SPACE VILLAGE APARTMENTS FILING No. 1

A SUBDIVISION OF LAND LOCATED IN THE NORTHWEST 1/4 OF SECTION 17, TOWNSHIP 14 SOUTH, RANGE 65 WEST OF THE SIXTH PRINCIPAL MERIDIAN, COUNTY OF EL PASO, STATE OF COLORADO

SHEET 1 OF 1

# SPACE VILLAGE APARTMENTS FILING No. 1

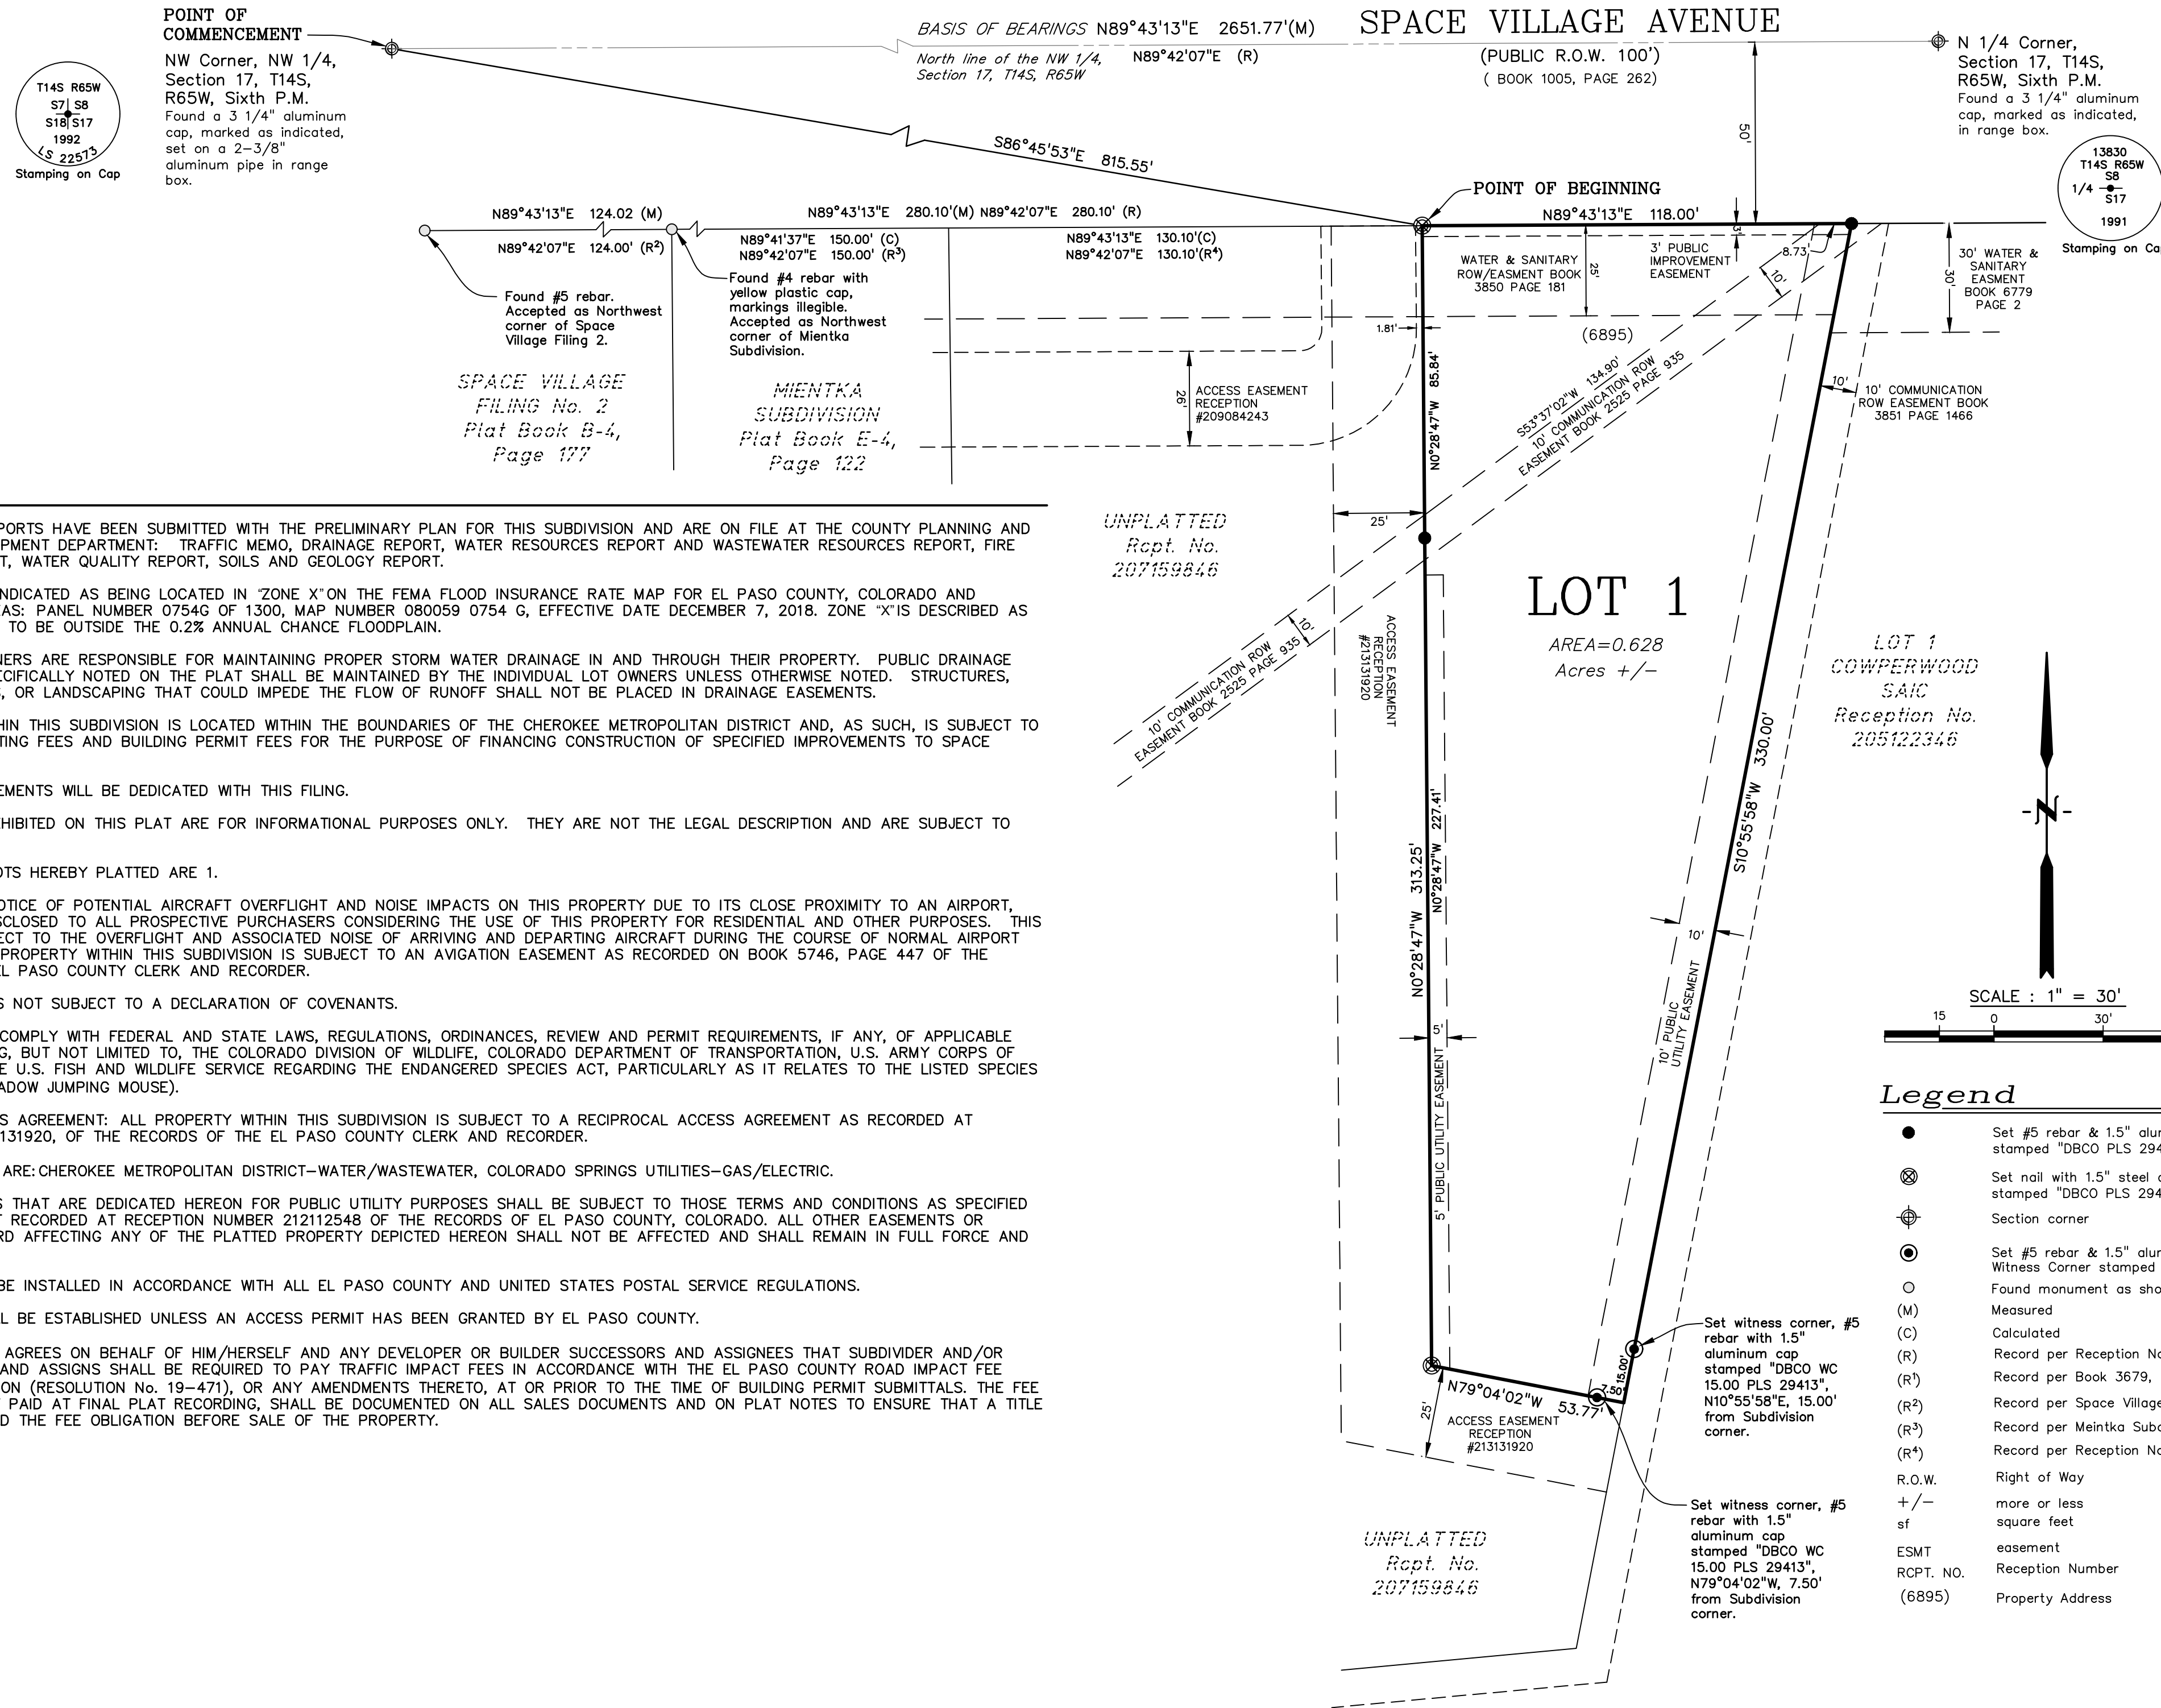
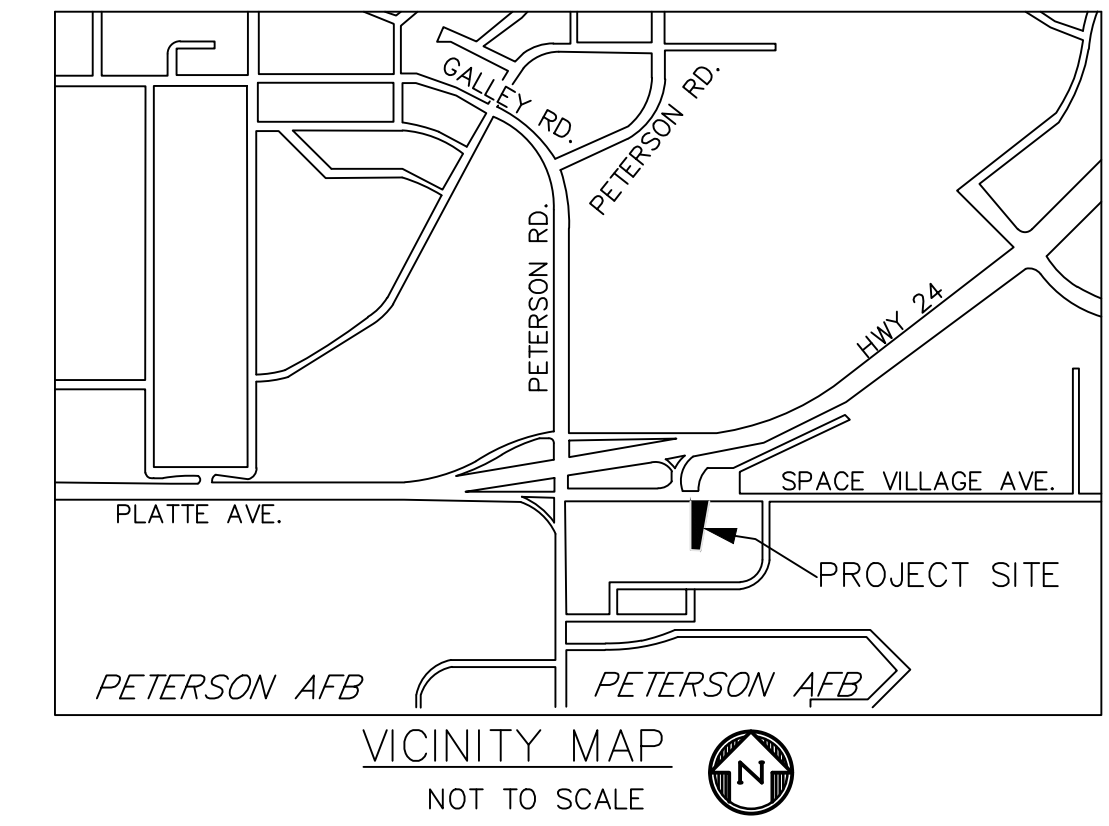
Landscape plan has not been submitted with this plat. If you wish to have a landscape plan recorded with this plat, one will need to be submitted. Otherwise, will be addressed with site development plan.

Covenants were not submitted with this plat. Clarify if covenants will be submitted and if not, remove this note or rephrase to indicate that subdivision is not subject to covenants.

Add note for Mailboxes: Mailboxes shall be installed in accordance with all El Paso County and United States Postal Service regulations.

Add note for Access: No driveway shall be established unless an access permit has been granted by El Paso County.

No SIA was submitted with this plat. If there are no public improvements, please revise this note to say no public improvements will be dedicated with this filing.

Add note: The Subdivider(s) agrees on behalf of him/herself and any developer or builder successors and assignees that Subdivider and/or said successors and assigns shall be required to pay traffic impact fees in accordance with the El Paso County Road Impact Fee Program Resolution (Resolution No. 16-454), or any amendments thereto, at or prior to the time of building permit submittals. The fee obligation, if not paid at final plat recording, shall be documented on all sales documents and on plat notes to ensure that a title search would find the fee obligation before sale of the property.

Where the Property is Located in the Airport Overlay Zone NOTICE OF POTENTIAL AIRCRAFT OVERFLIGHT AND NOISE IMPACT ASSOCIATED WITH AIRPORT: This serves as notice of potential aircraft overflight and noise impacts on this property due to its close proximity to an airport, which is being disclosed to all prospective purchasers considering the use of this property for residential and other purposes. This property is subject to the overflight and associated noise of arriving and departing aircraft during the course of normal airport operations. (Use when this plat is to provide the notice) All property within this subdivision is subject to a Notice of Potential Aircraft Overflight and Noise Impact recorded at Reception No. _____ of the records of the El Paso County Clerk and Recorder. (Use when the Notice has previously been recorded) All property within this subdivision is subject to an Avigation Easement as recorded at Reception No. _____ of the records of the El Paso County Clerk and Recorder. (Use only when the property is subject to an existing avigation easement as reflected in the title policy)

No tracts on this plat

This plat does not meet the criteria for administrative approval. Include signature block for BOCC approval.
